Please ask for: Mrs D Johnson
Email: daun.johnson@arun.gov.uk
Telephone: 01903 737762
Our Ref: BR/55/20/PL
Your Ref:
Date: 31st March 2020

Application for Planning Permission

Development: Proposed first and second floor extensions
Location: Abbots Lawn Sylvan Way Bognor Regis PO21 2RS

Proposed North Elevation

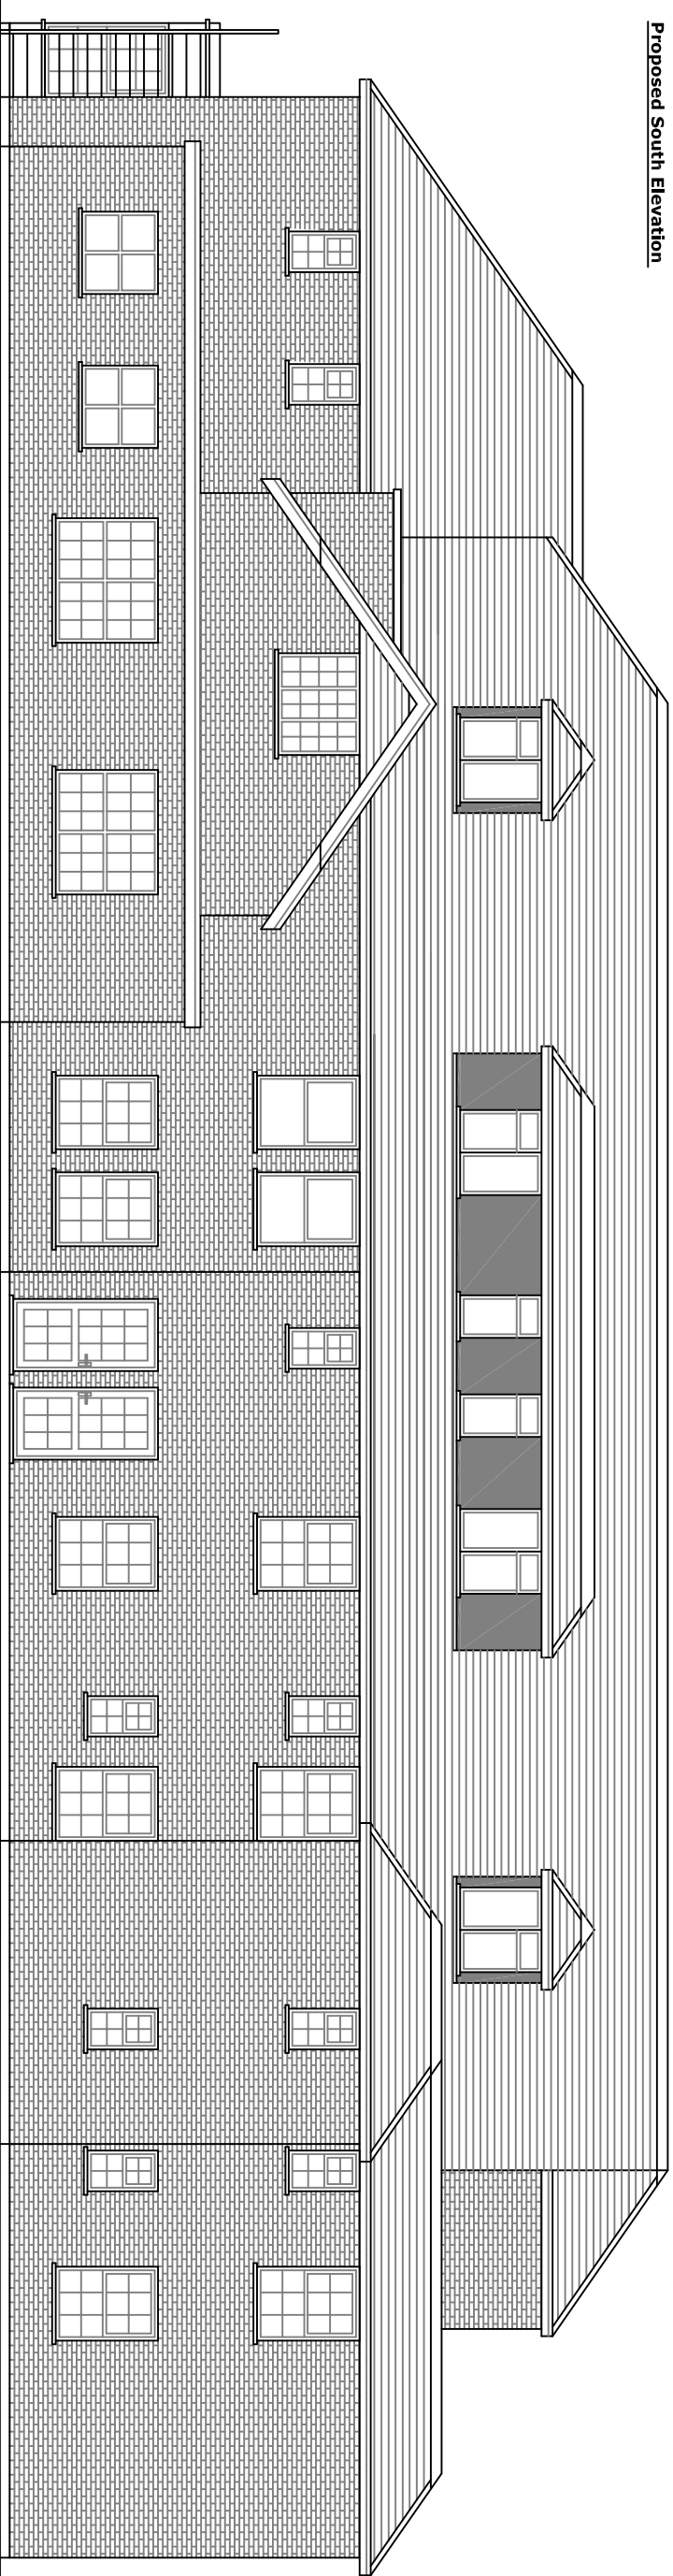
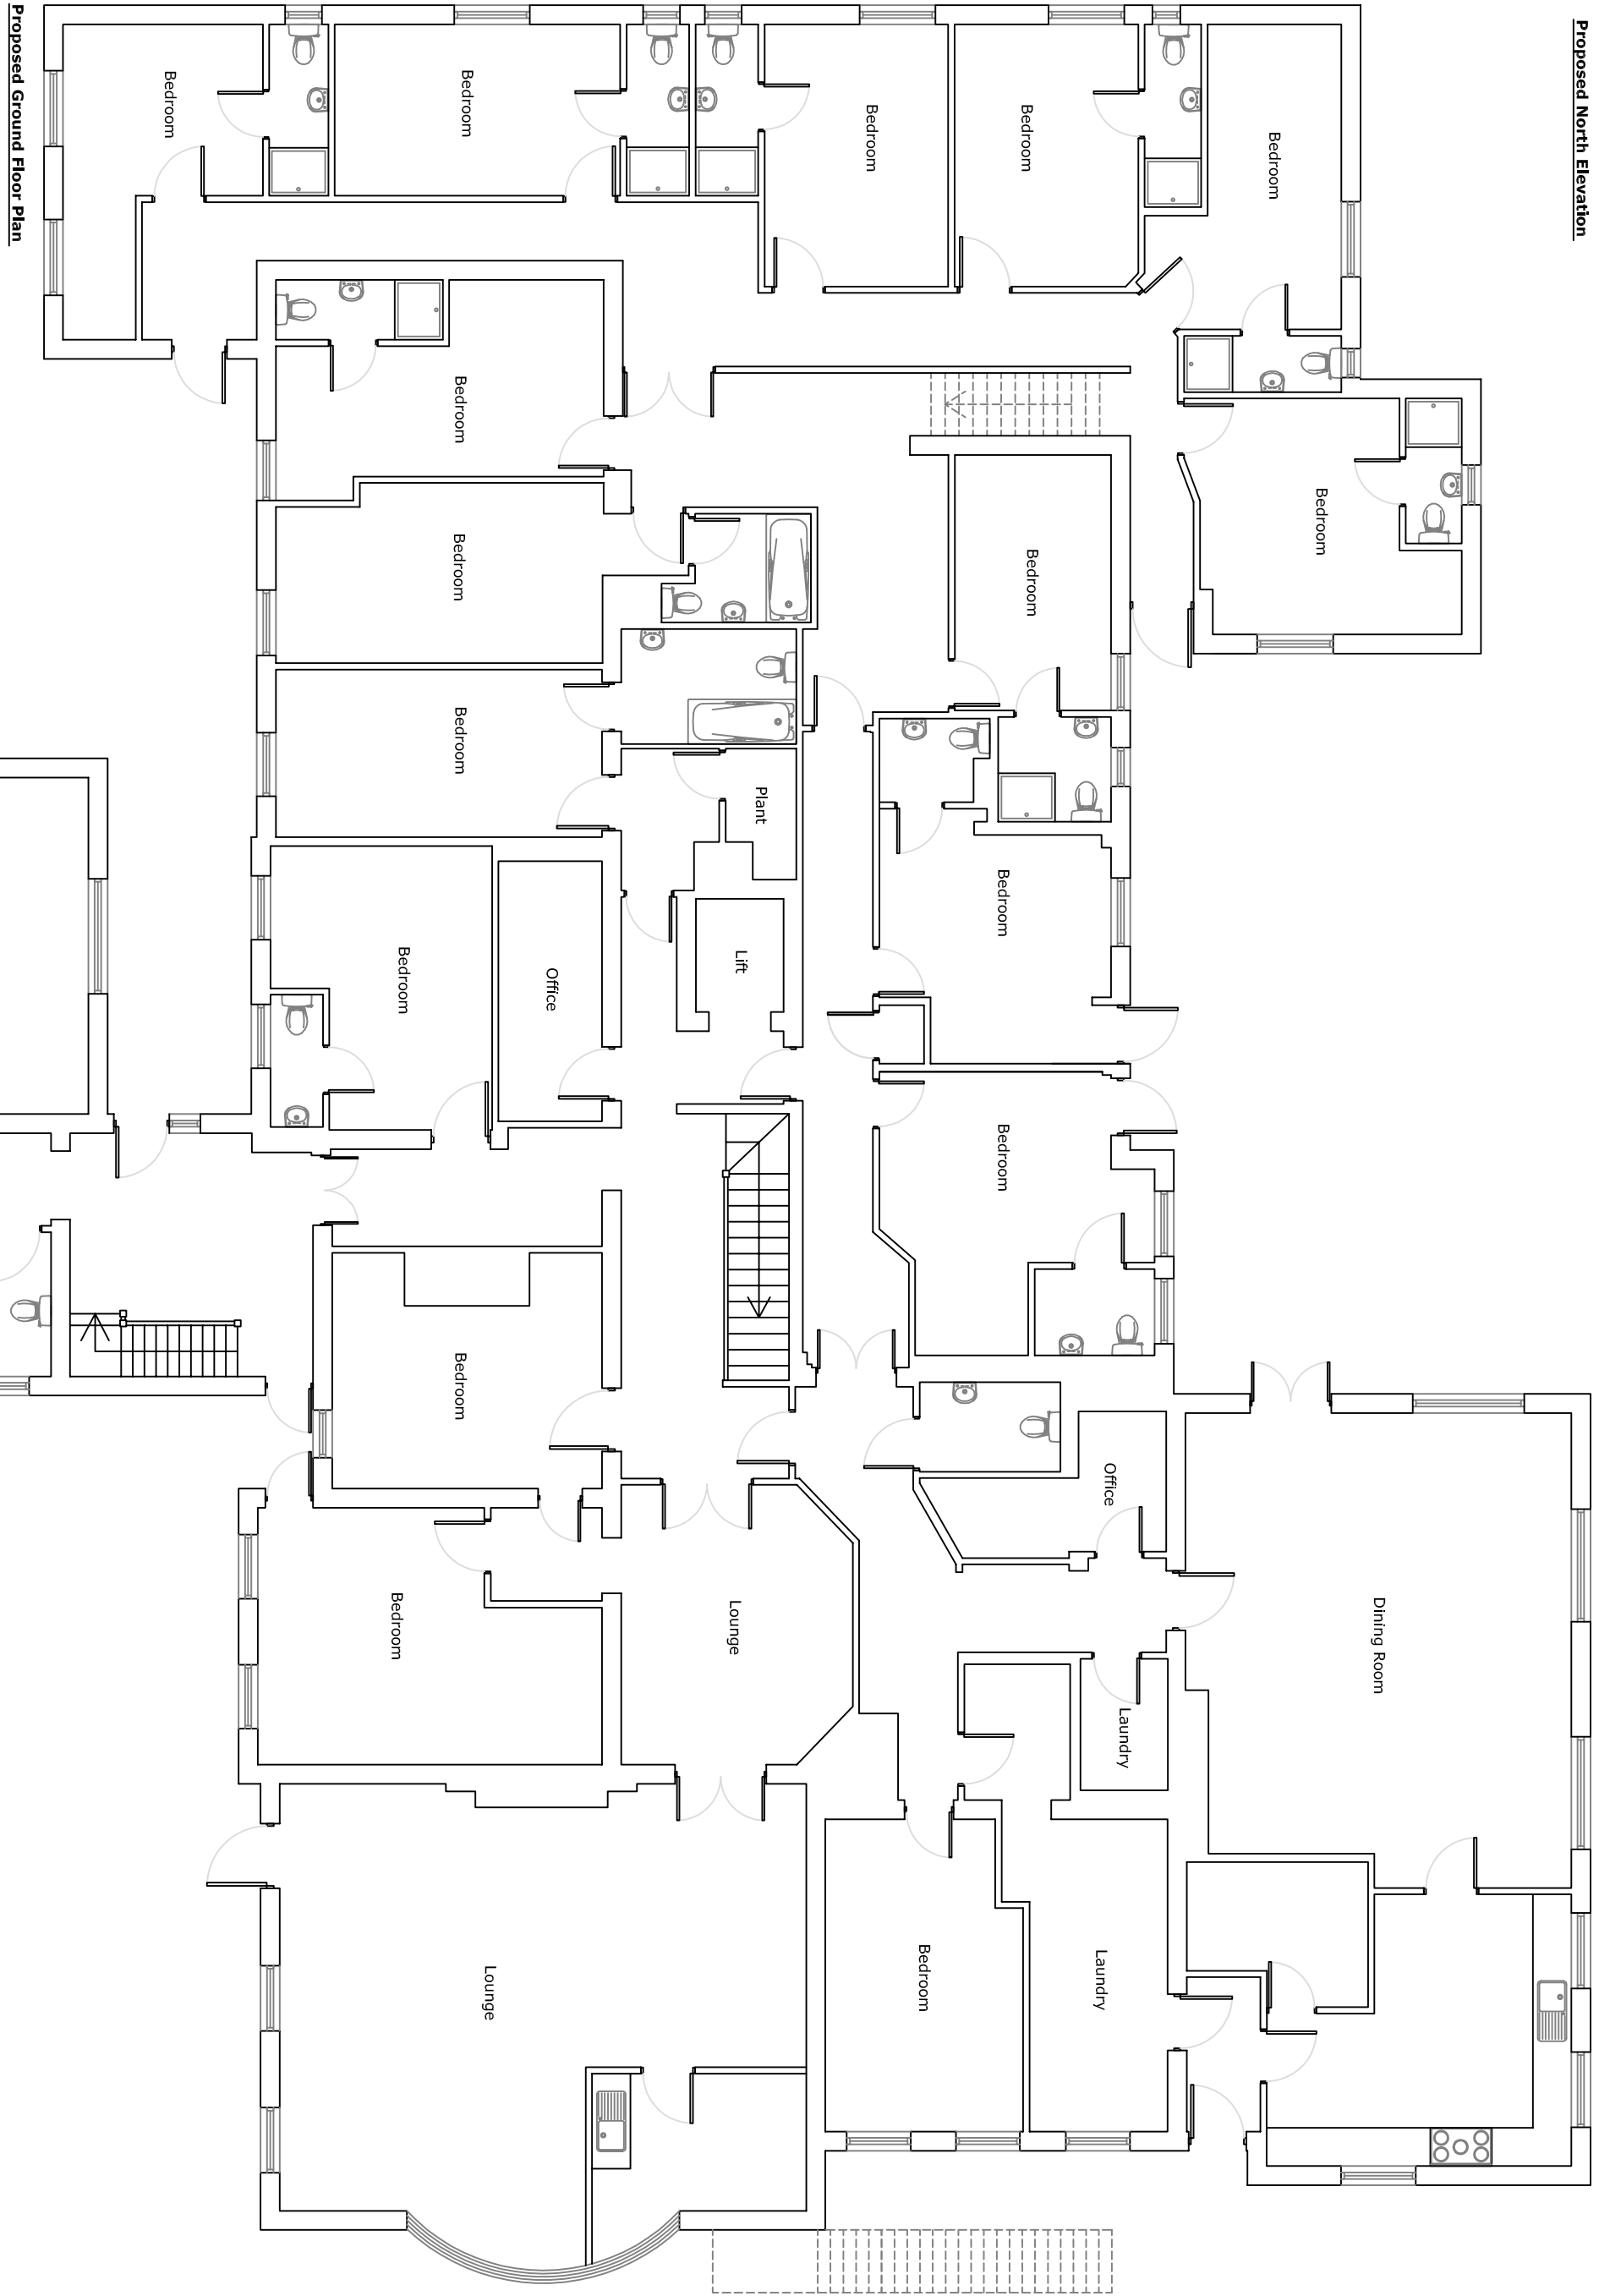
Please show the staircase on the north floor plan to accord with the north elevations.
